Submission on 104 - 116 Regent St, Redfern SSD12618001

By 1 Margaret St Owners Corporation

17 February 2022

1 Margaret St Elevation
Elevation 1 : 200

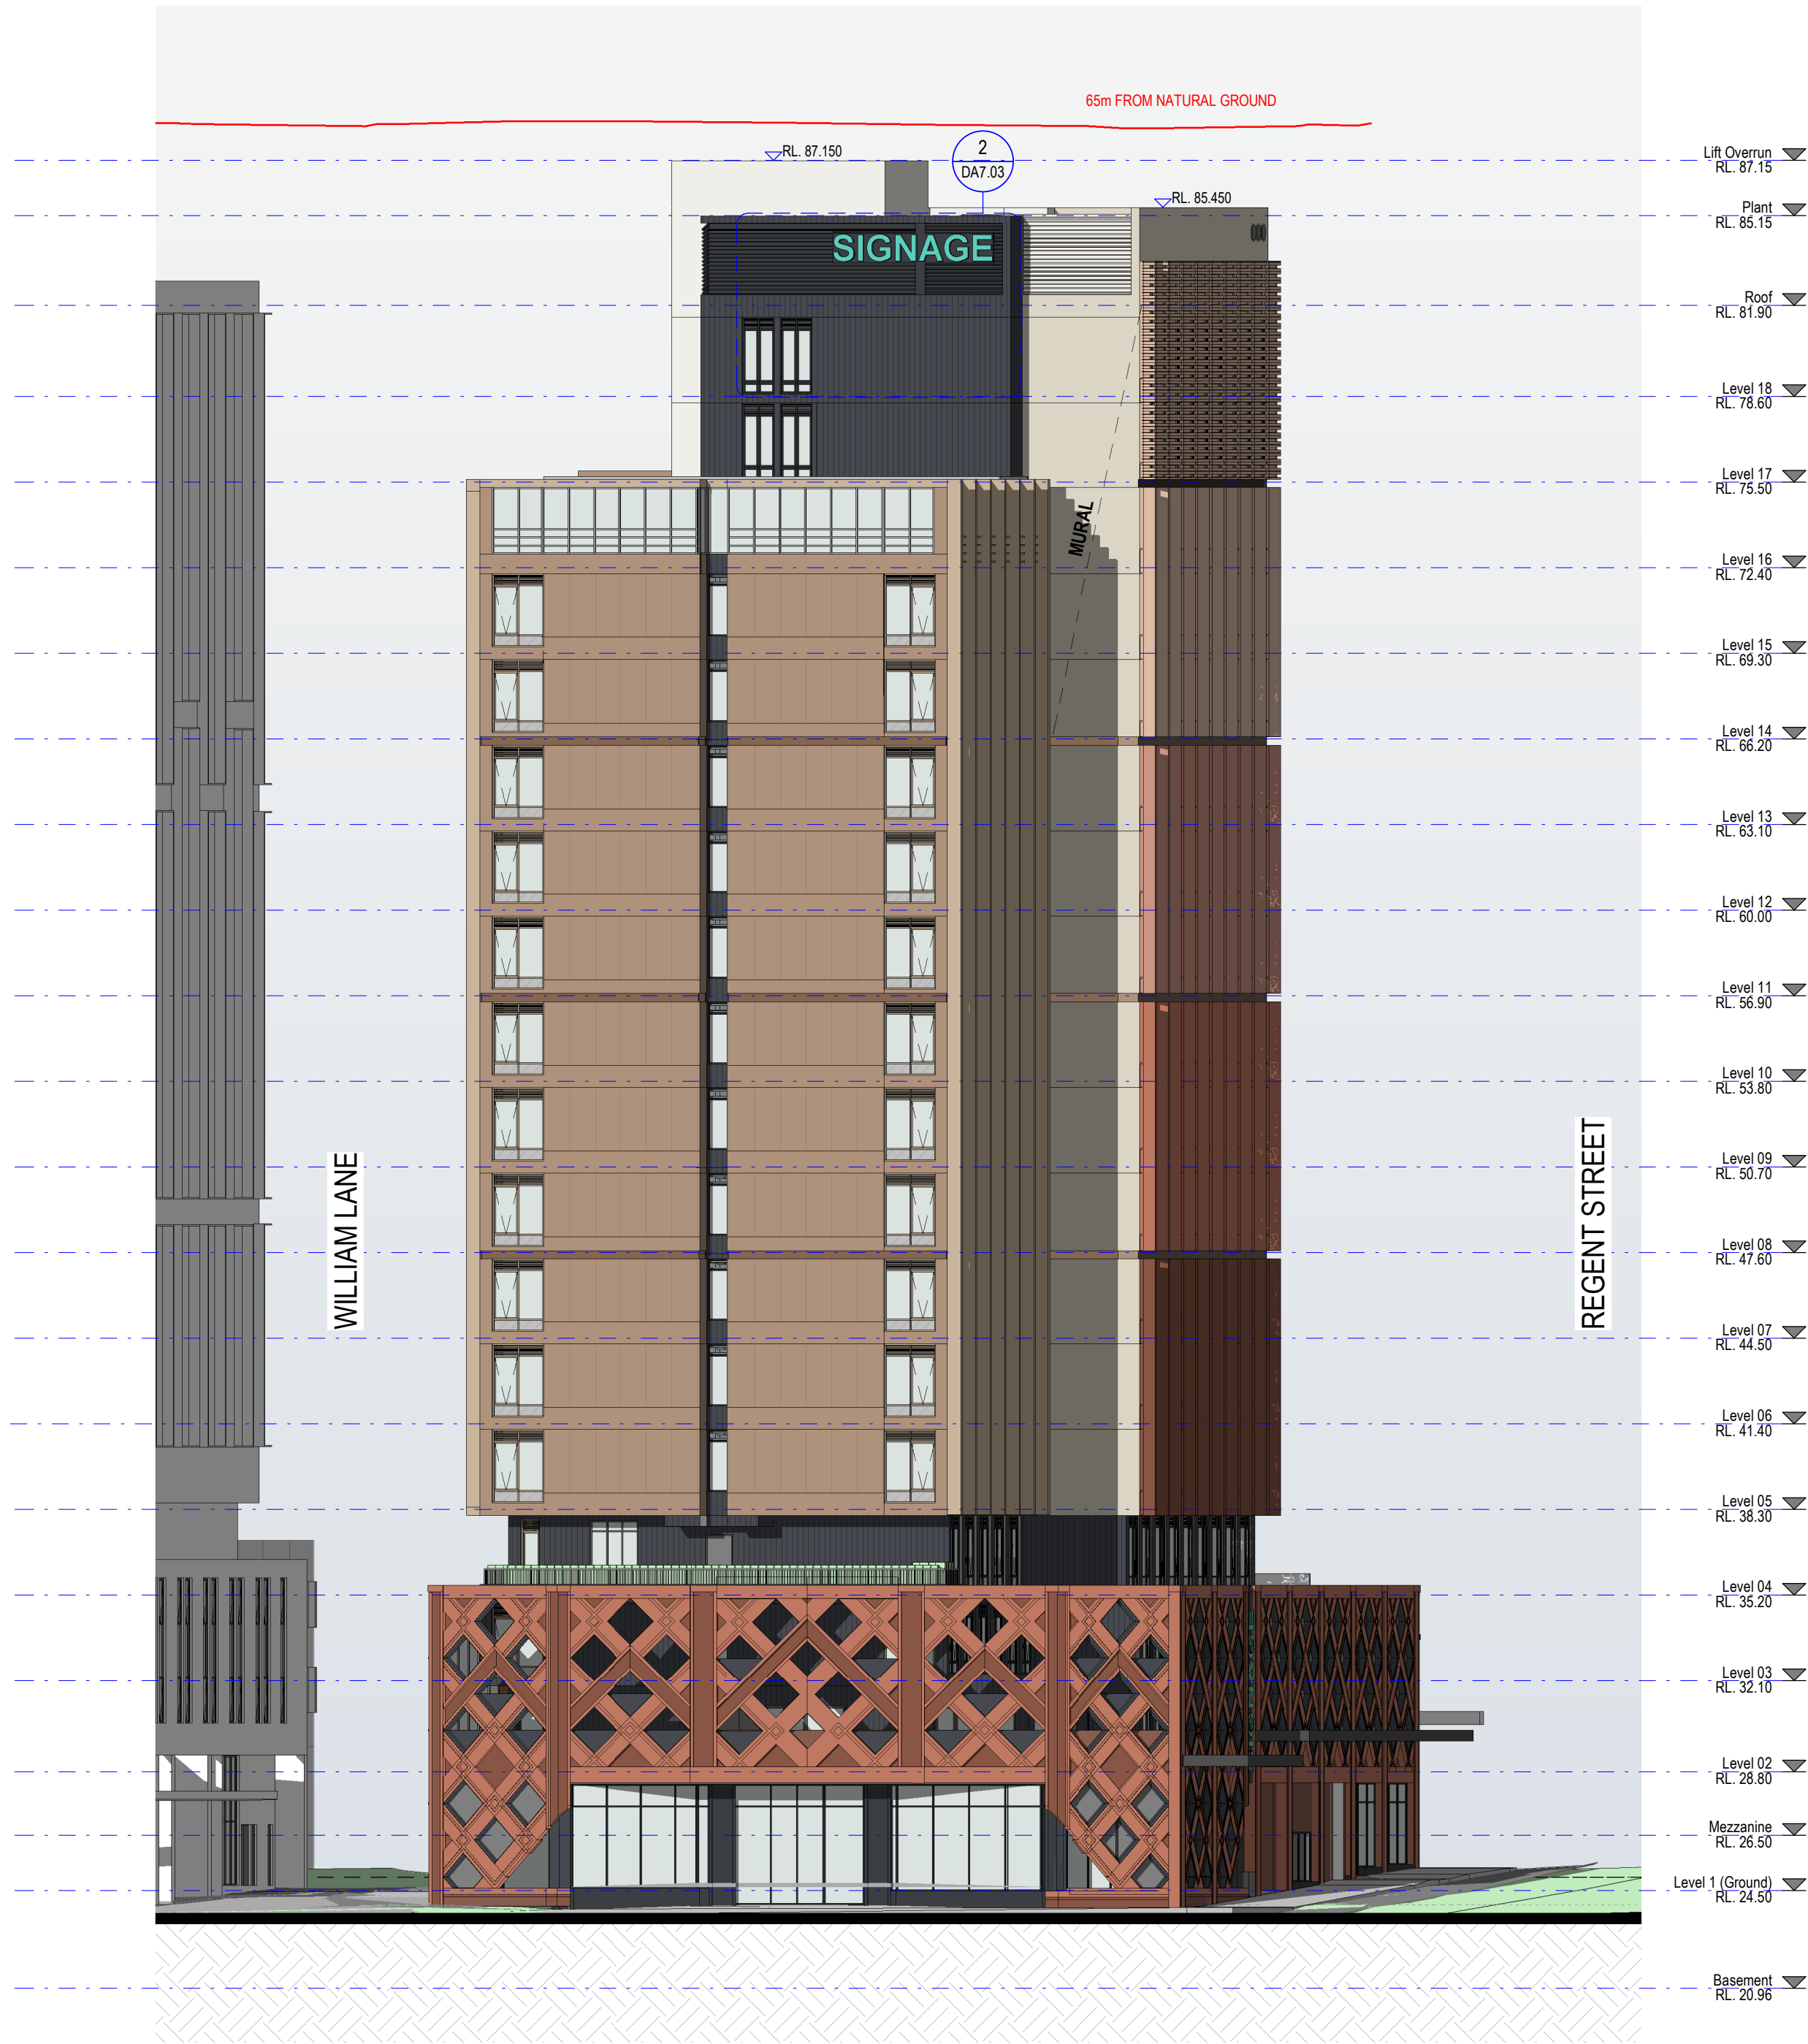
- The wind sensors were only placed at street level in Margaret St - a number of residential apartments in Margaret St and William Lane have outdoor balconies / terraces on the 2/3/4 levels. No measurements or assessments were conducted to assess impacts above street level in these residential areas.
- There is no commitment provided by Wee Hur for monitoring post construction to assess whether wind tunneling impacts are acceptable and potentially implement further mitigation measures if required.
